CITY OF PORTLAND, MAINE
DEVELOPMENT REVIEW APPLICATION
PLANNING DEPARTMENT PROCESSING FORM
ADDENDUM

Shepherd Ln/Lot #10

CITY OF PORTLAND, MAINE
 SITE PLAN REVIEW (ADDENDUM)
 CONDITIONS OF APPROVAL

RE: Request for Certificate of Occupancy
82 Shepherd Lane (lot 10)

Site Plan For:  
Lot 10 Orchard Green  
82 Shepherd Lane  
Portland, Maine

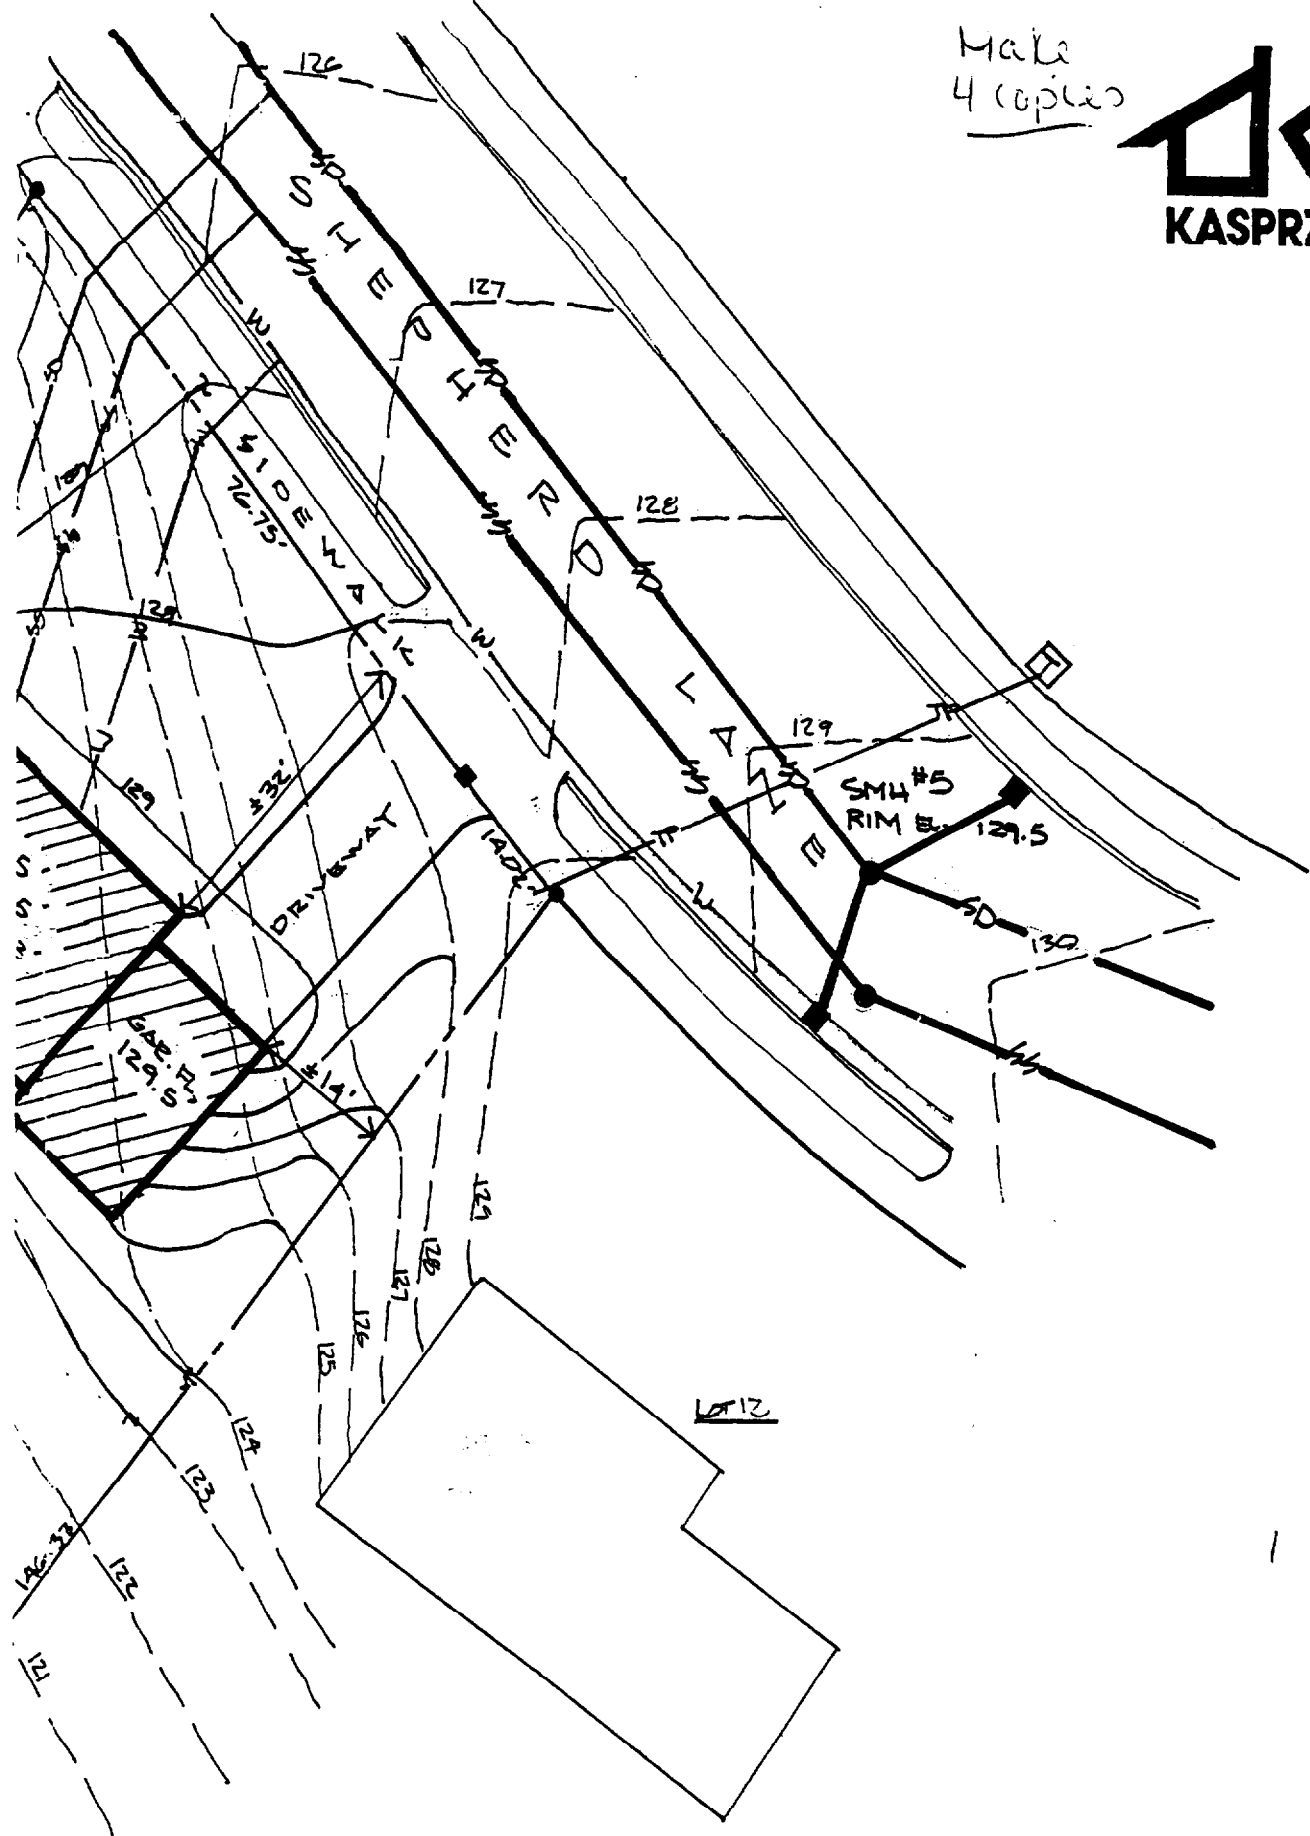
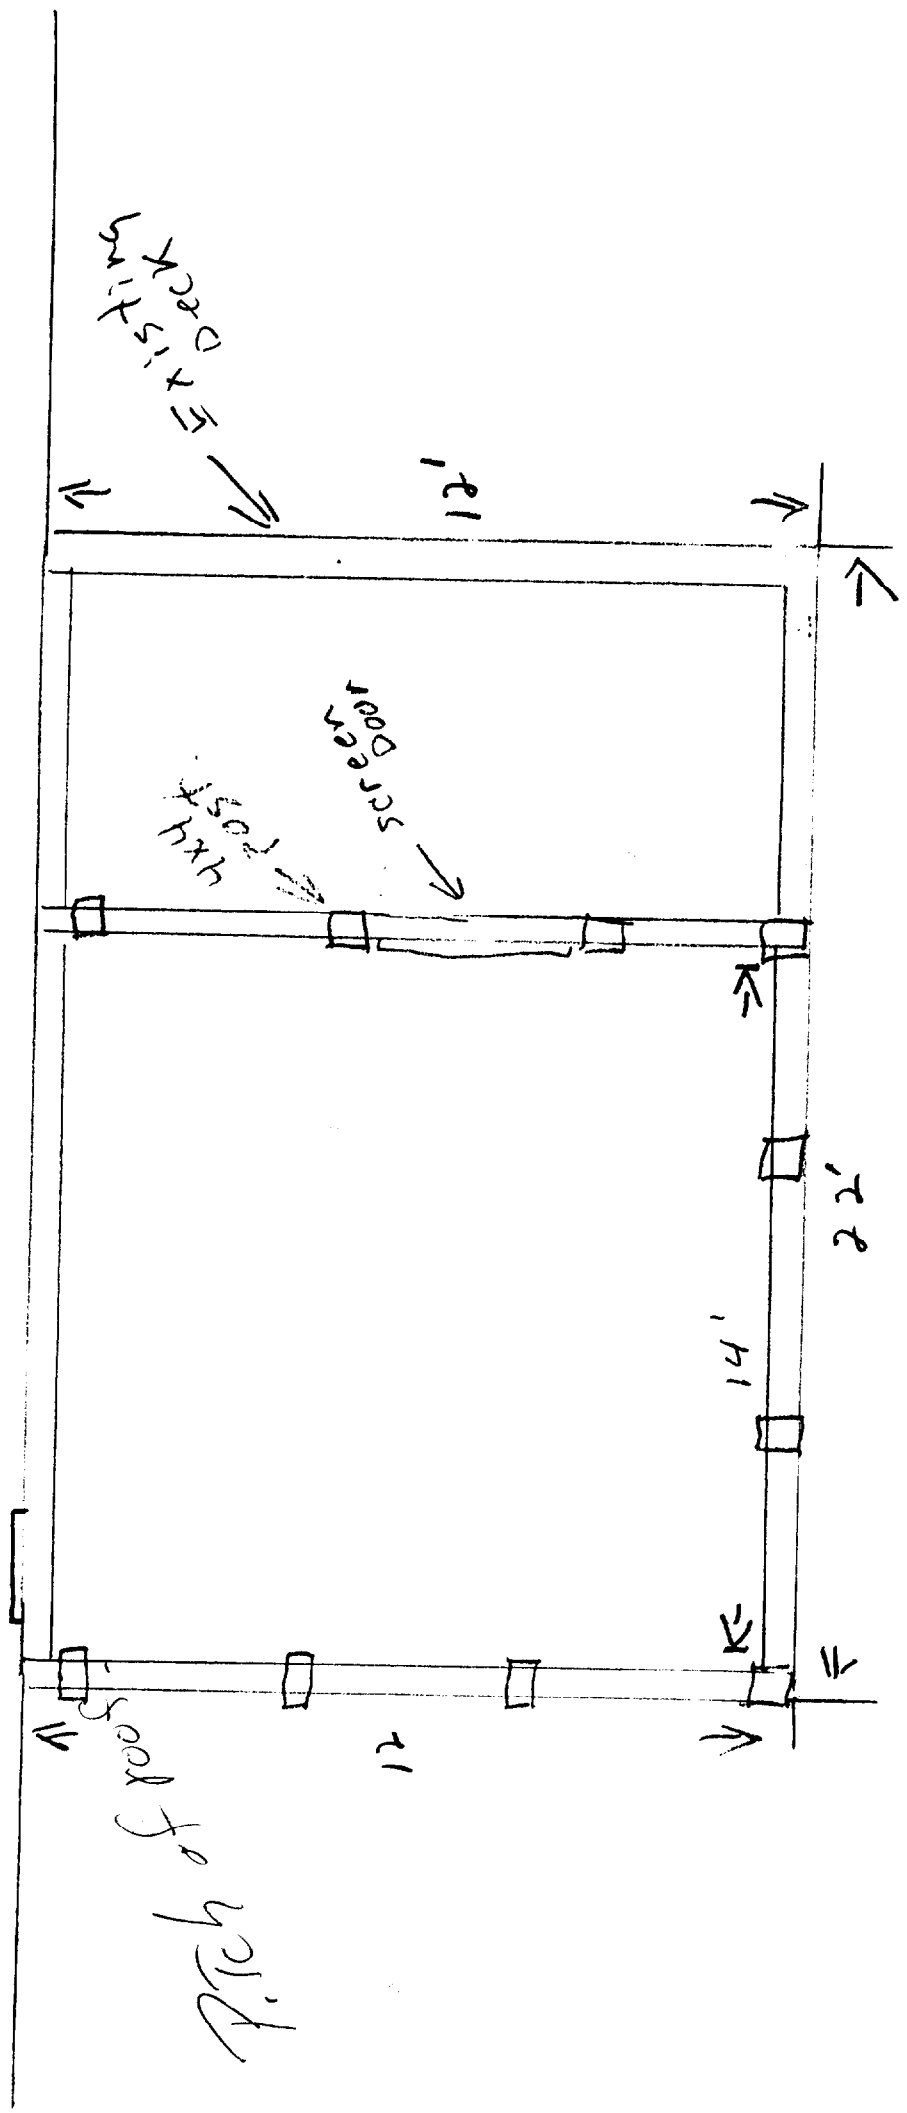
Silt fence shall be installed approximately 10' down gradient of the disturbed area.

13. SILT FENCE SHALL BE INSTALLED APPROX
10' DOWN GRADIENT OF THE DISTURBED AREA.

1. The final grading is complete but the lot is not seeded. To protect and hold the loam in place, all slopes steeper than 4:1 must be heavily mulched. This should include the flat area at the base of the rear exterior stairway. This is the rainy season.
2. The number for the street address must be placed on the street frontage of the house.
3. Public Works does have the required as-built data for the sanitary and storm sewers.
